**RE: Appaloosa Hwy Sub Fil No. 1A, Lot 2
PCD File No. PPR193**

The following comments were addressed:

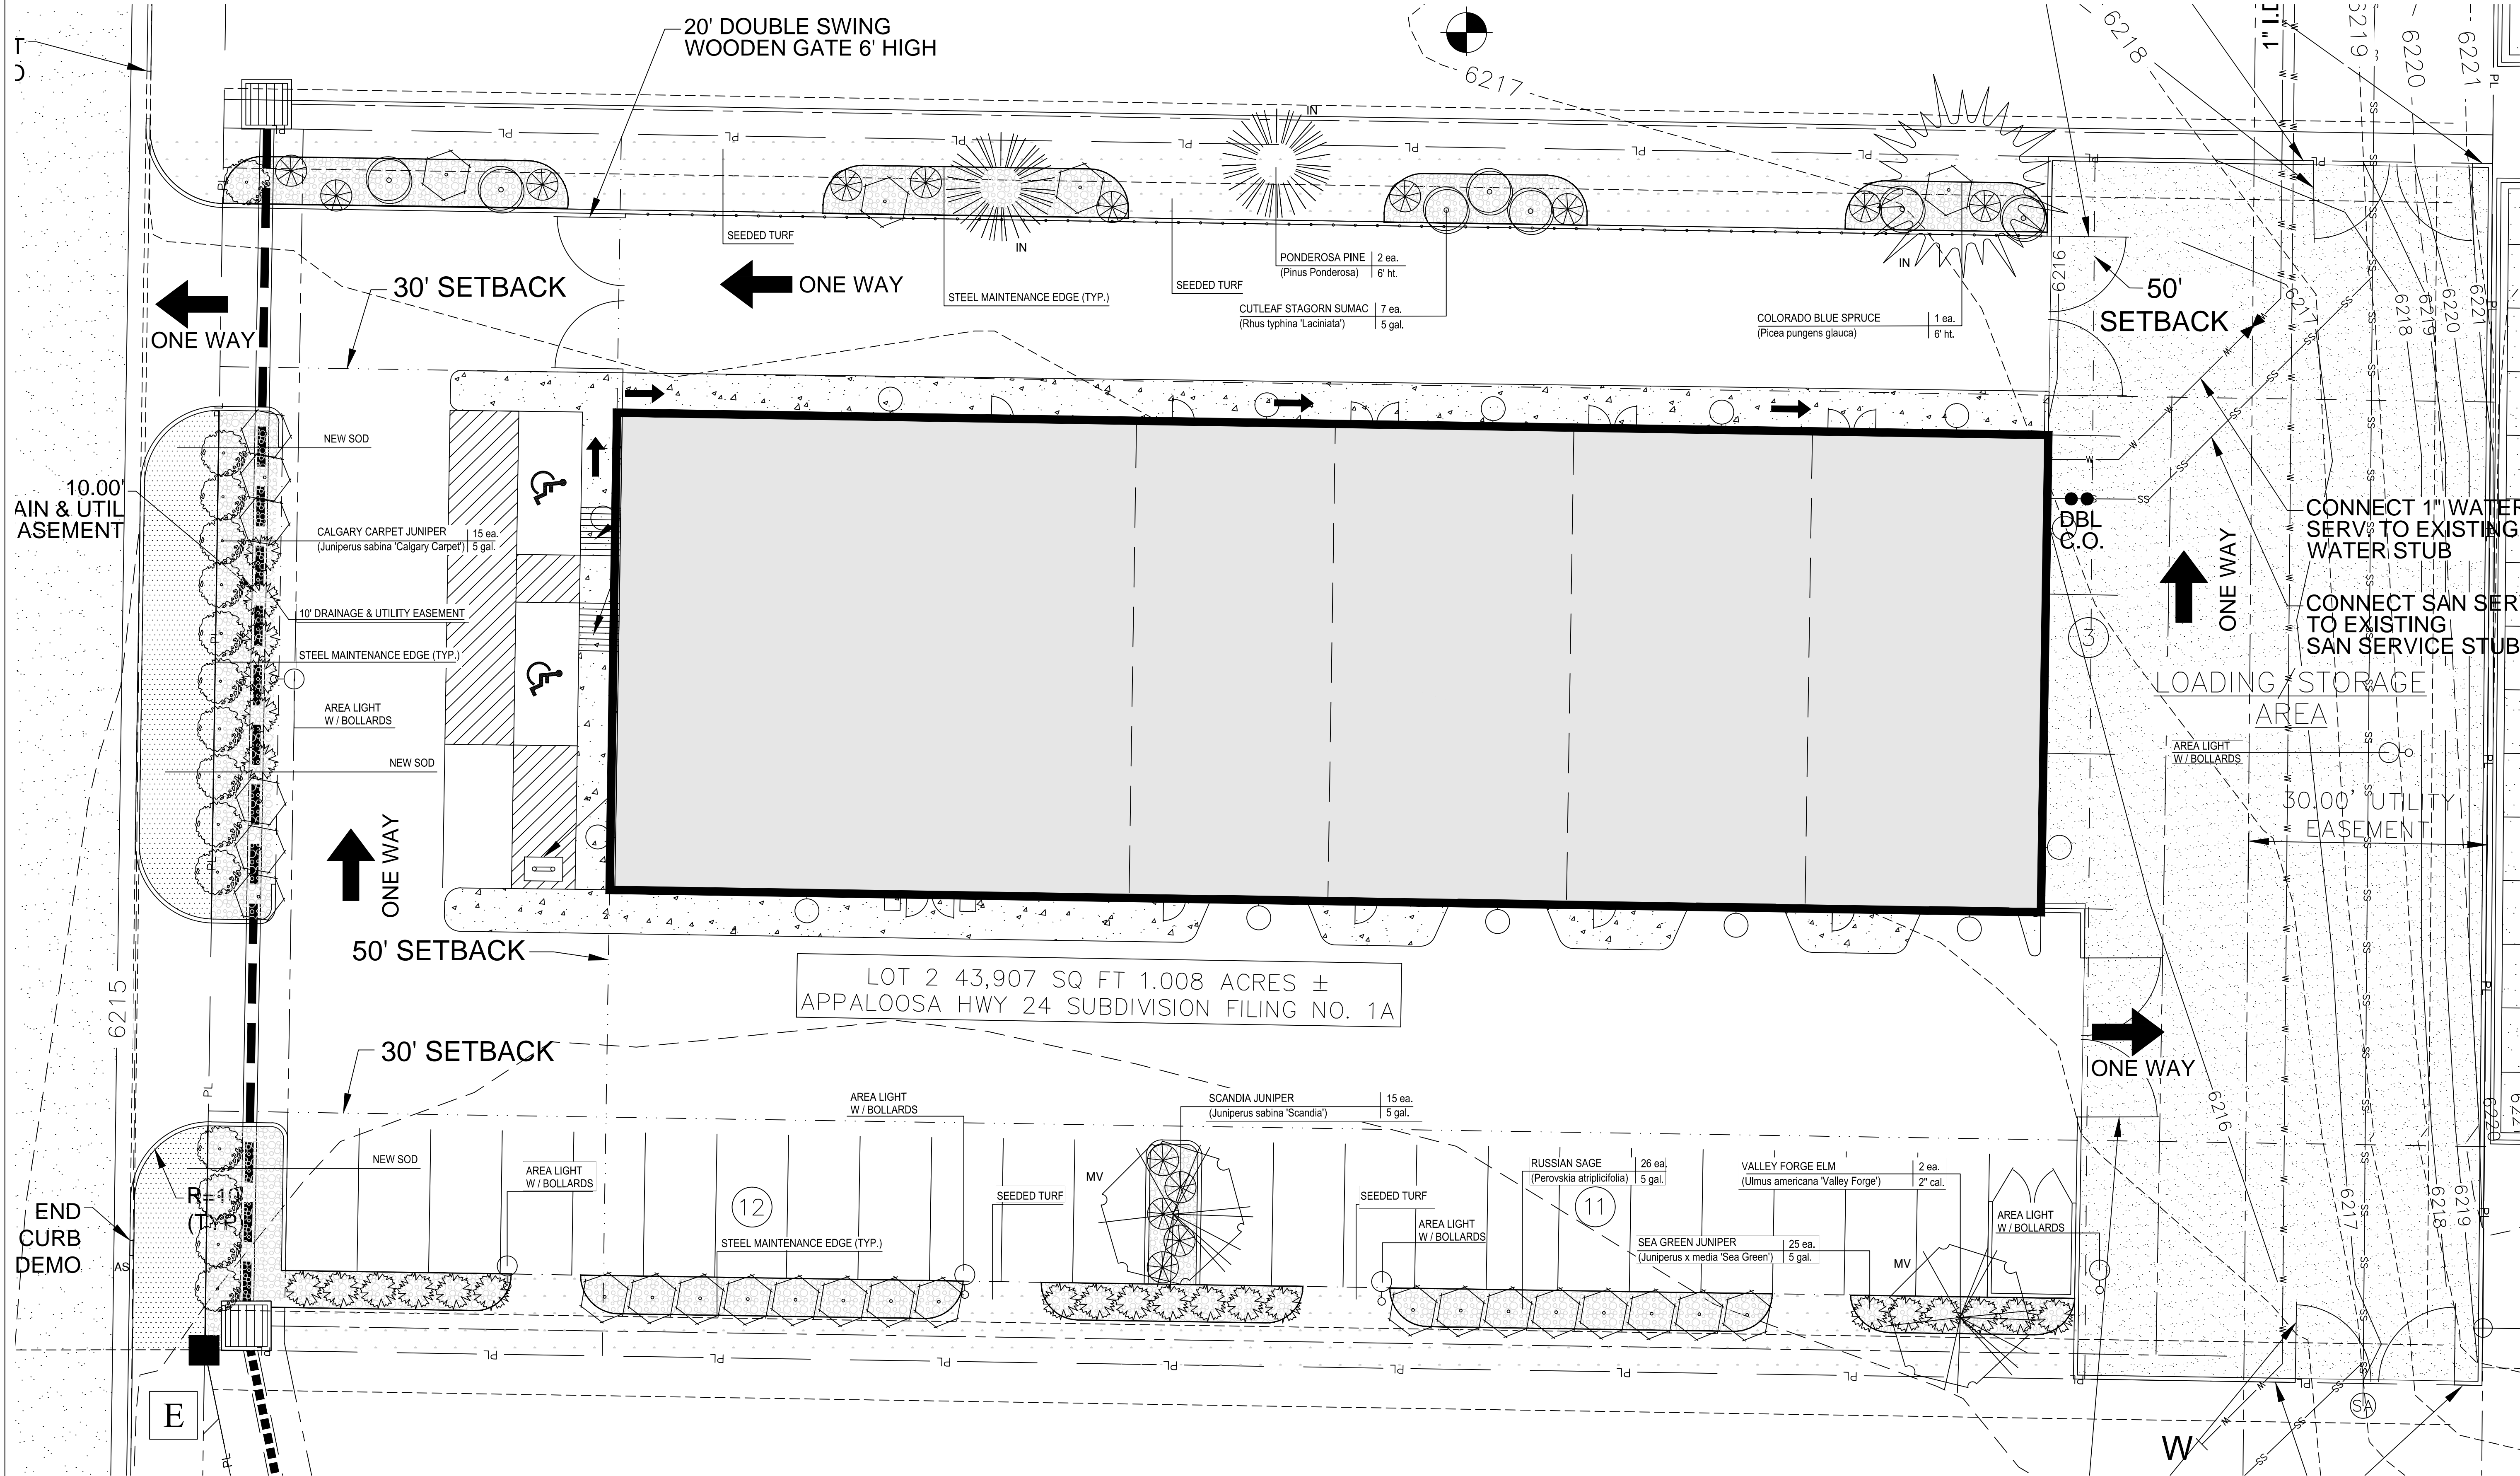
Landscape Plan
Plan revised to reflect site revisions

NAME	SHEET #S
GRADING AND EROSION CONTROL COVER	1
DRAINAGE, GRADING & EROSION CONTROL PLAN	2
EROSION CONTROL DETAILS SH. 1	3
EROSION CONTROL DETAILS SH. 2	4

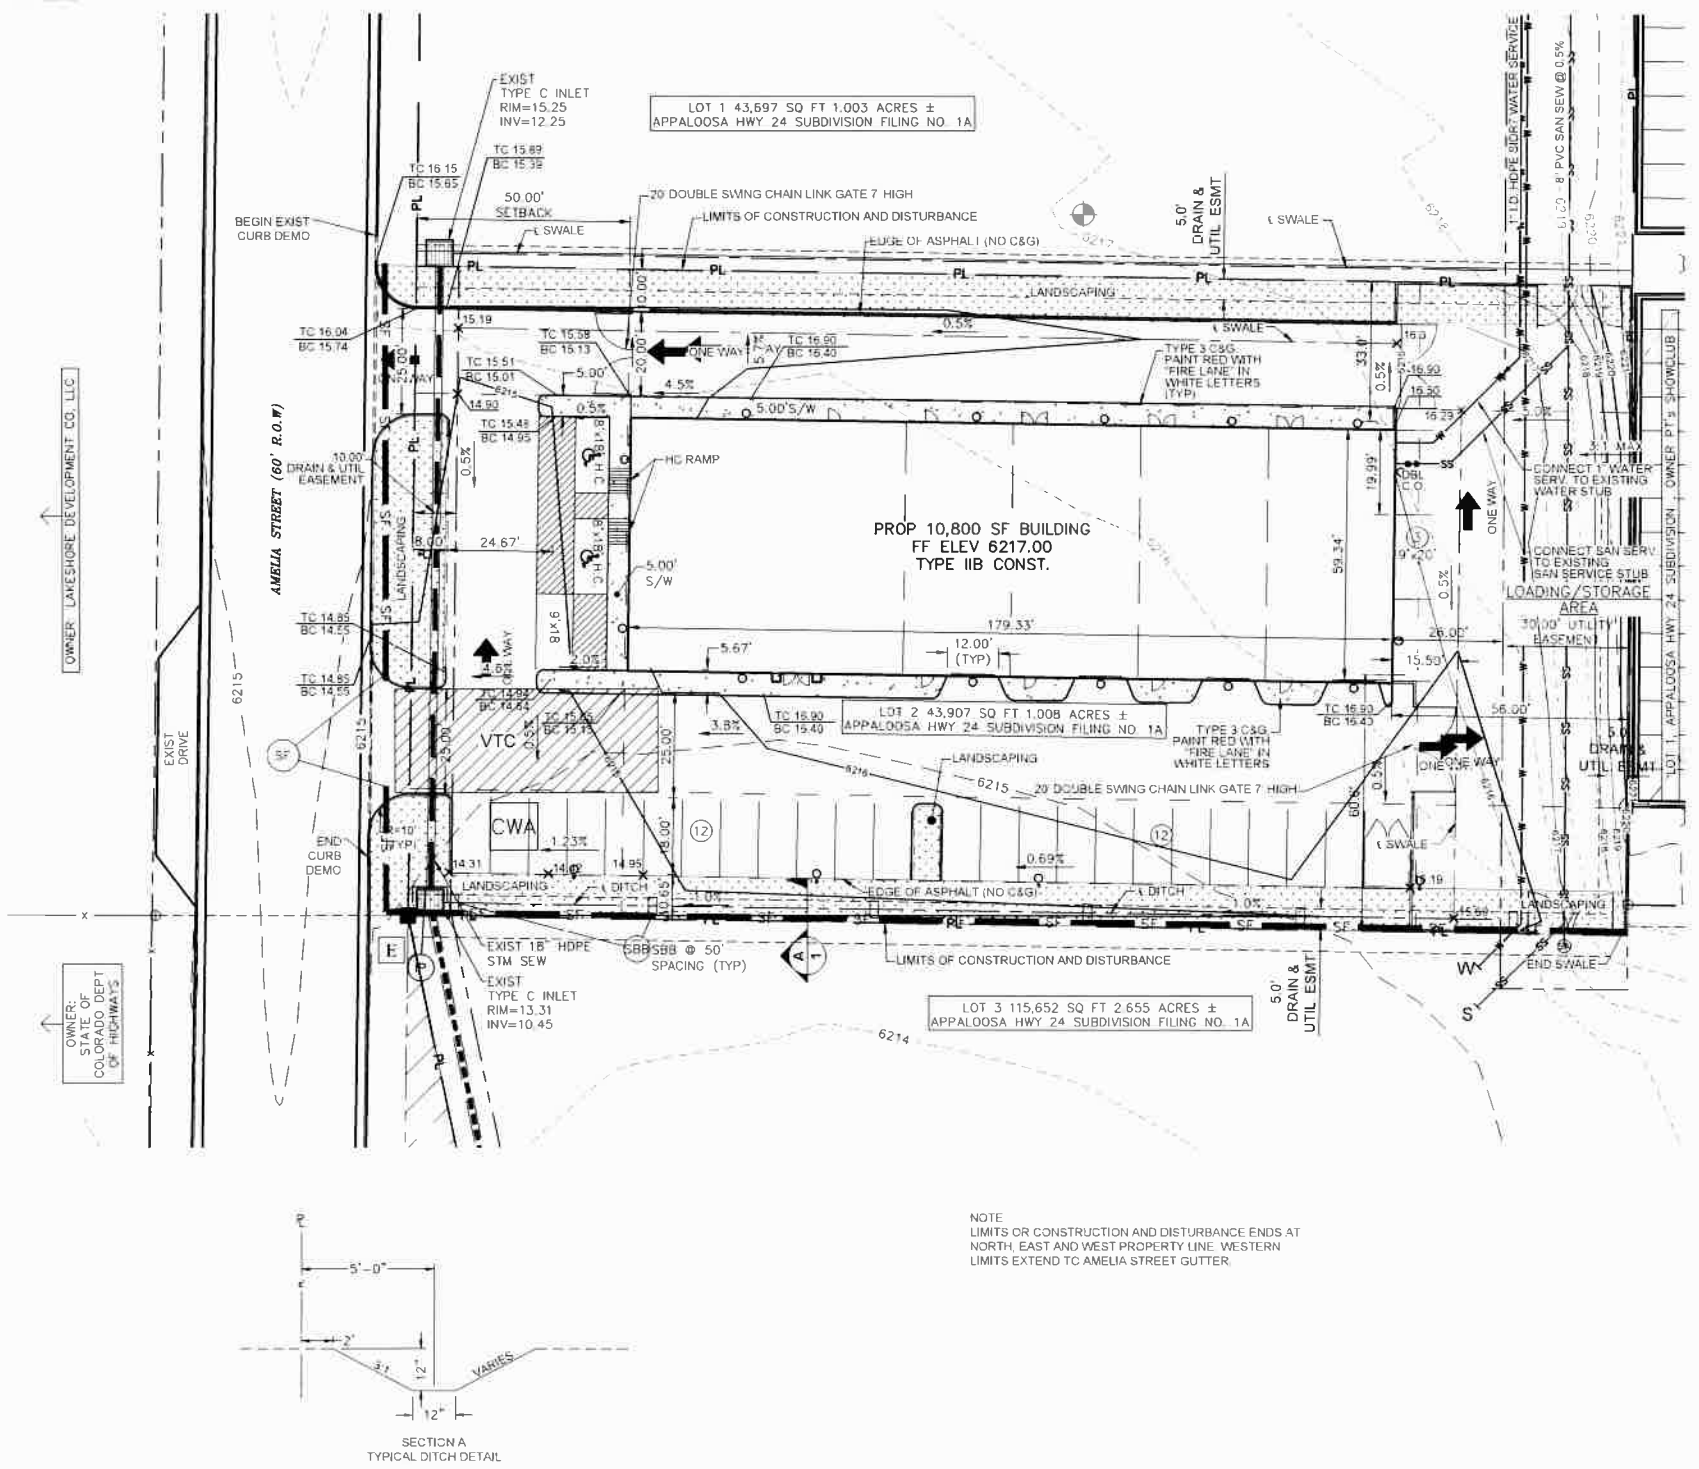
Cover Sheet notes revised
